August 22, 2007

RE: Estates of Longfellow Inn, 130 Eastern Promenade, (Application ID # 2007-0123)

Thank you for your application for a proposed renovation and building addition at 130 Eastern Promenade. Staff review of your application submissions has generated the following comments:

130 EASTERN PROMENADE

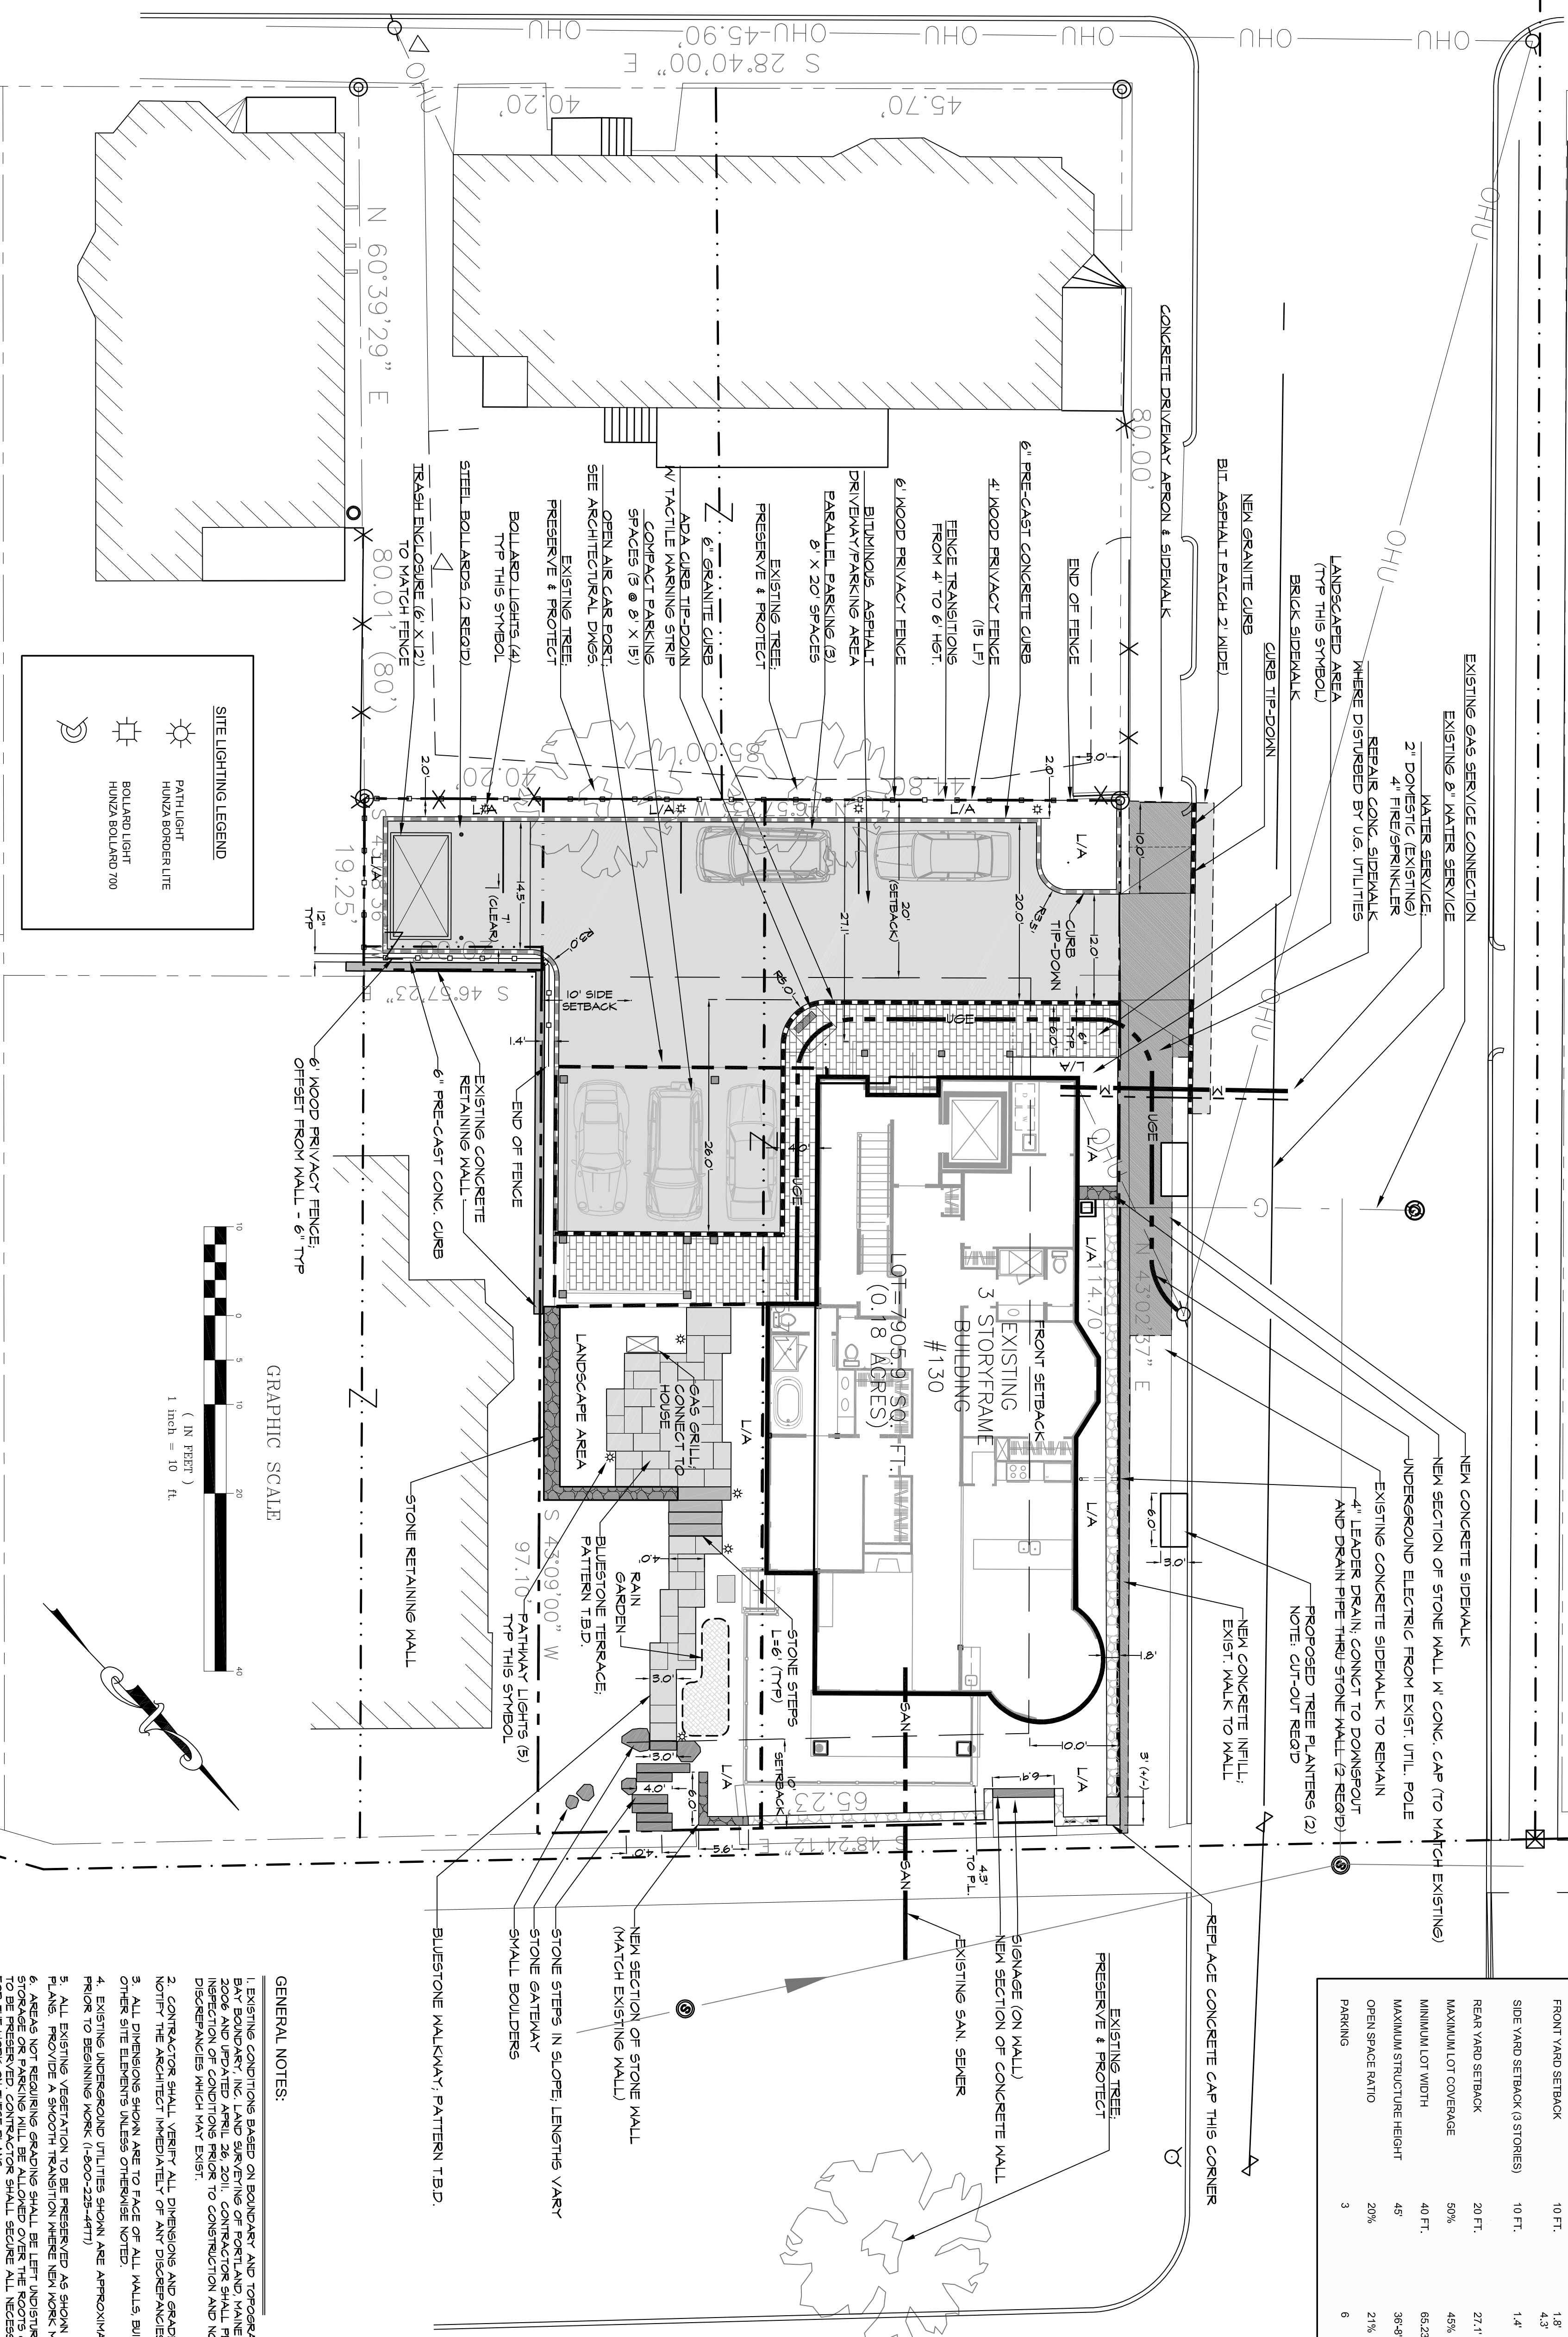
6. The parking proposal you have submitted must be revised. City Traffic Engineers have reviewed the submitted plans (sheet SK-3) and have determined that the proposed configuration is unworkable. Please reconfigure your parking proposal, addressing the following issues:

- a. The proposed driveway is too narrow. City Technical Standards require that two-way driveways for multi-family developments be a minimum of 24 feet wide.

- b. Only a portion of the driveway radius on the submitted plans proposes granite curbing. The full radius of the driveway should be designed and constructed of granite curb.

- c. The parking spaces on the proposed plans are too small. City Technical Standards define standard parking spaces as 9'x19'. You are permitted to incorporate compact spaces (7.5' x 15') for 35% of your total parking.

SITE GRADING
PLAN

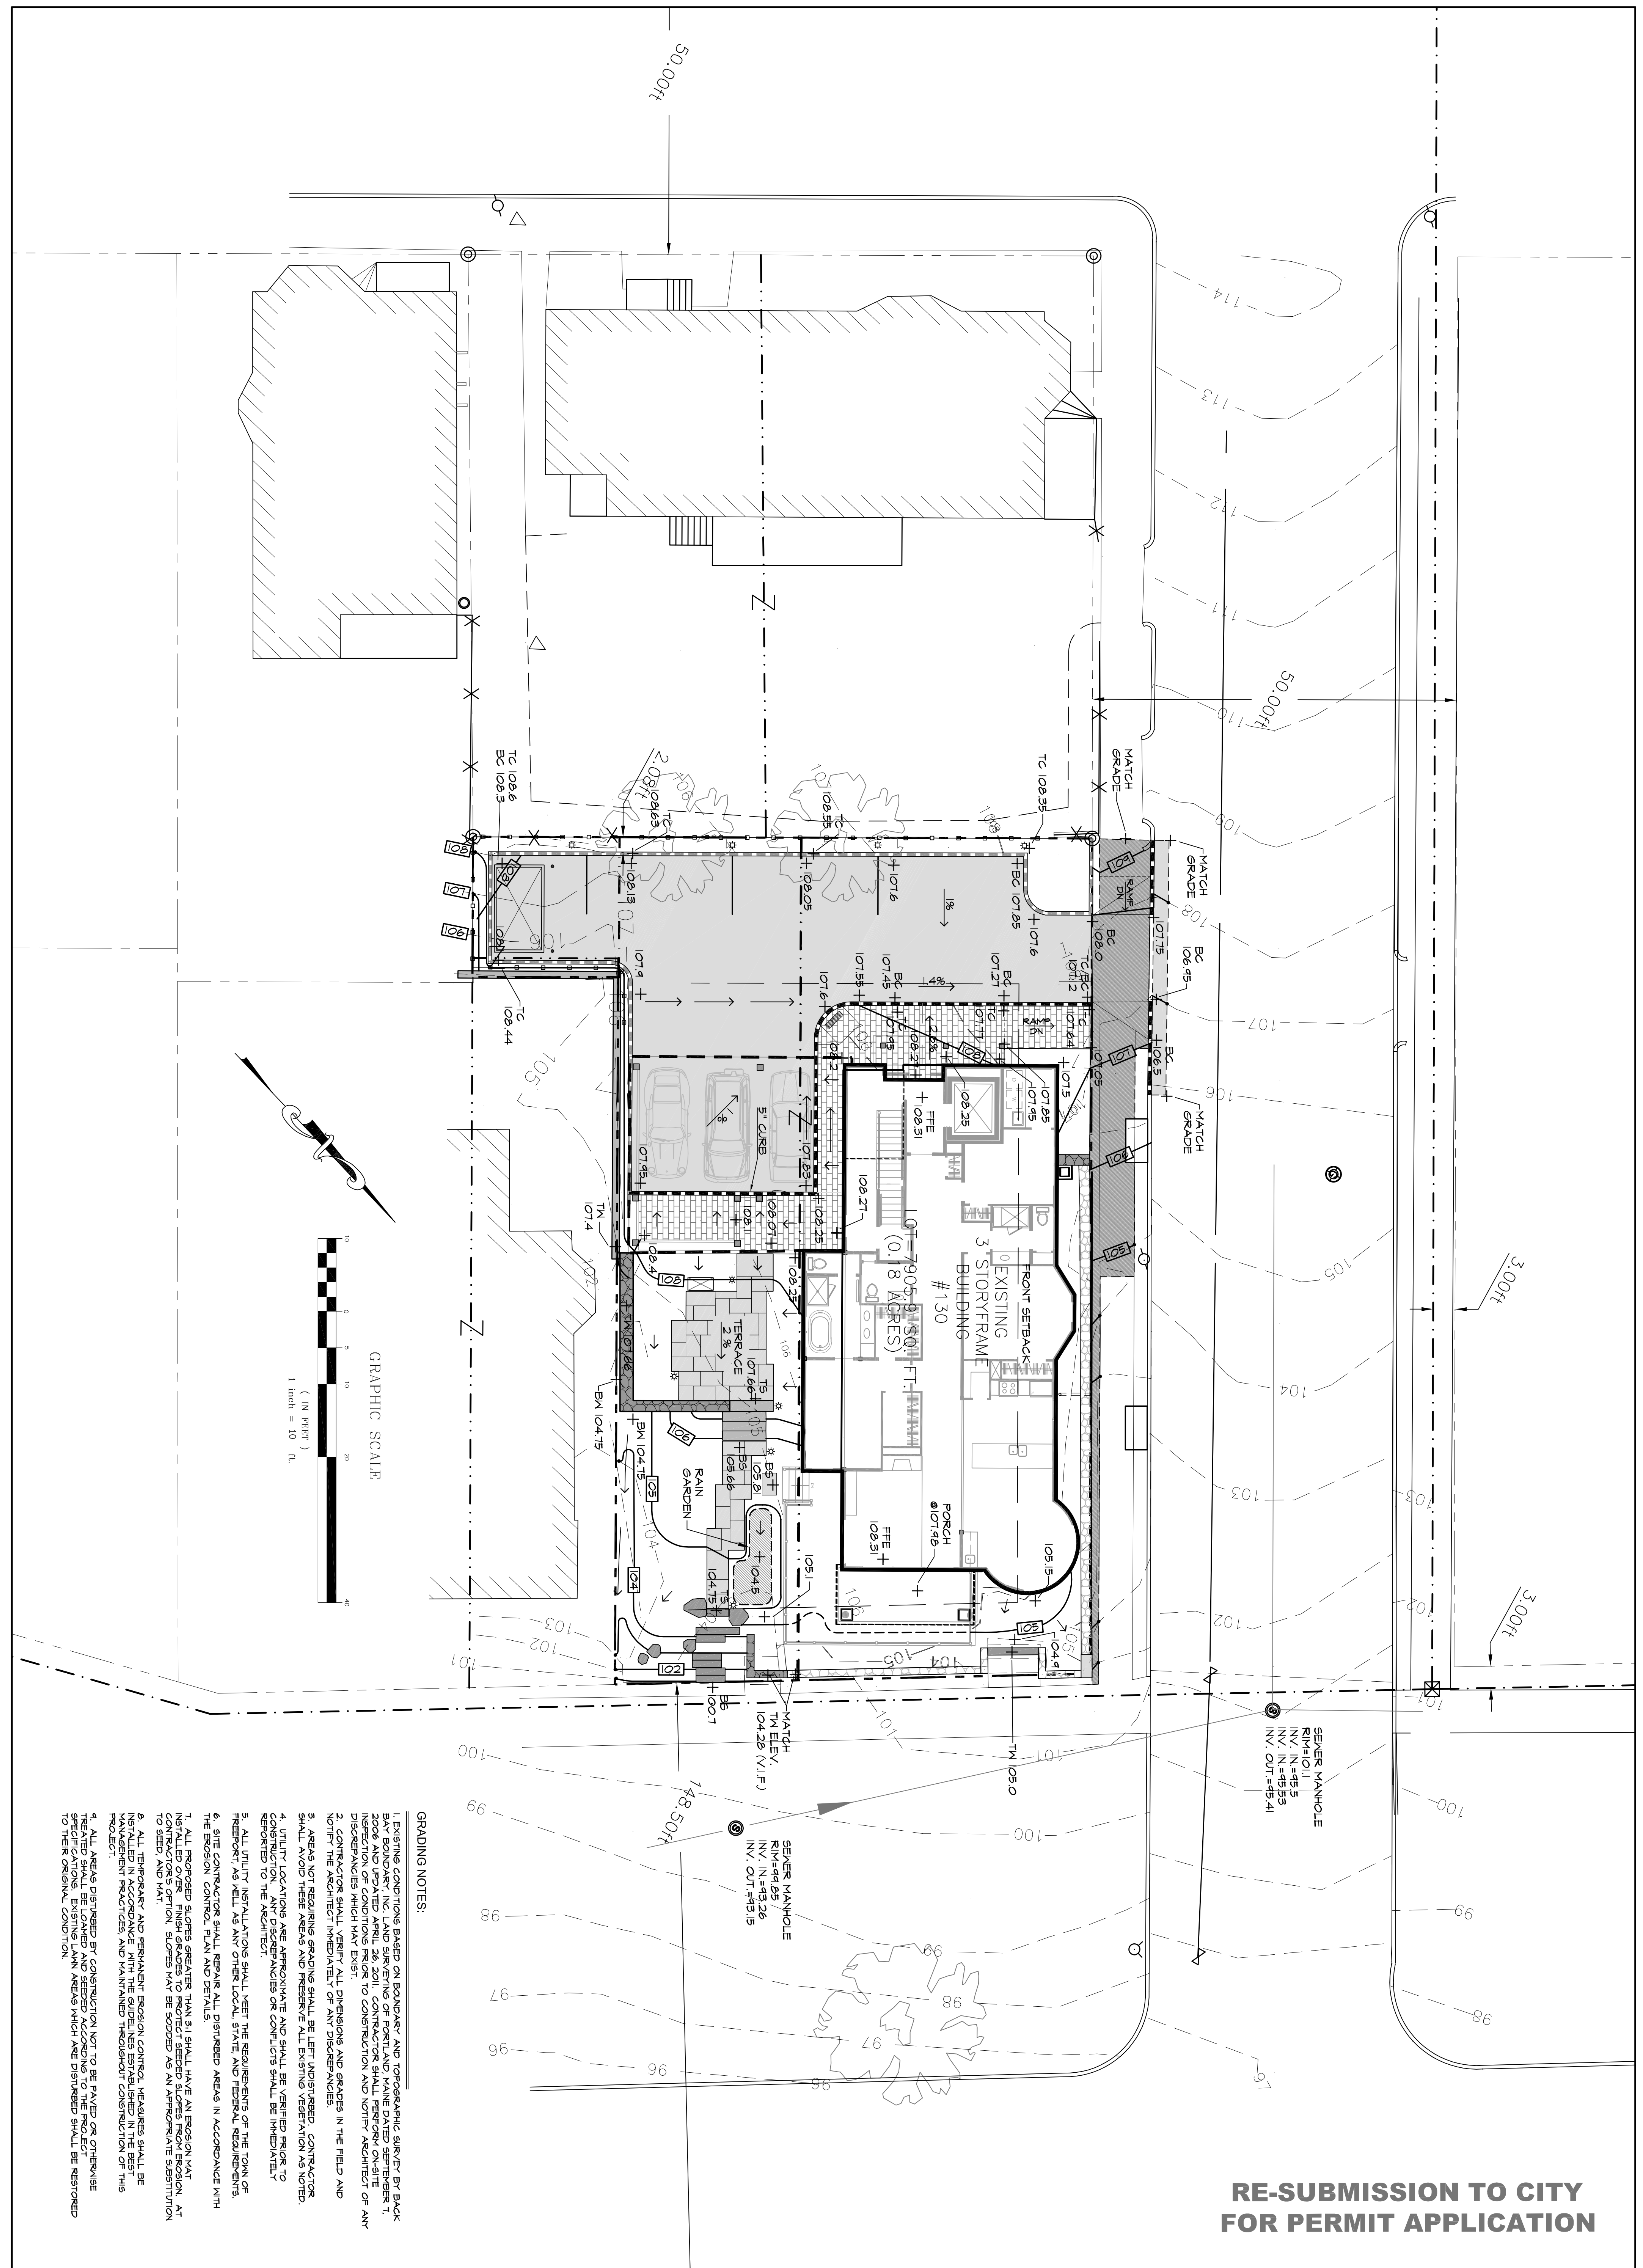
10. A drainage swale has been included on the submitted site plans at the northwestern corner of the building, near the section of pavers. Please provide grading and details for this swale. This swale may need to be taken into consideration in the stormwater calculations.
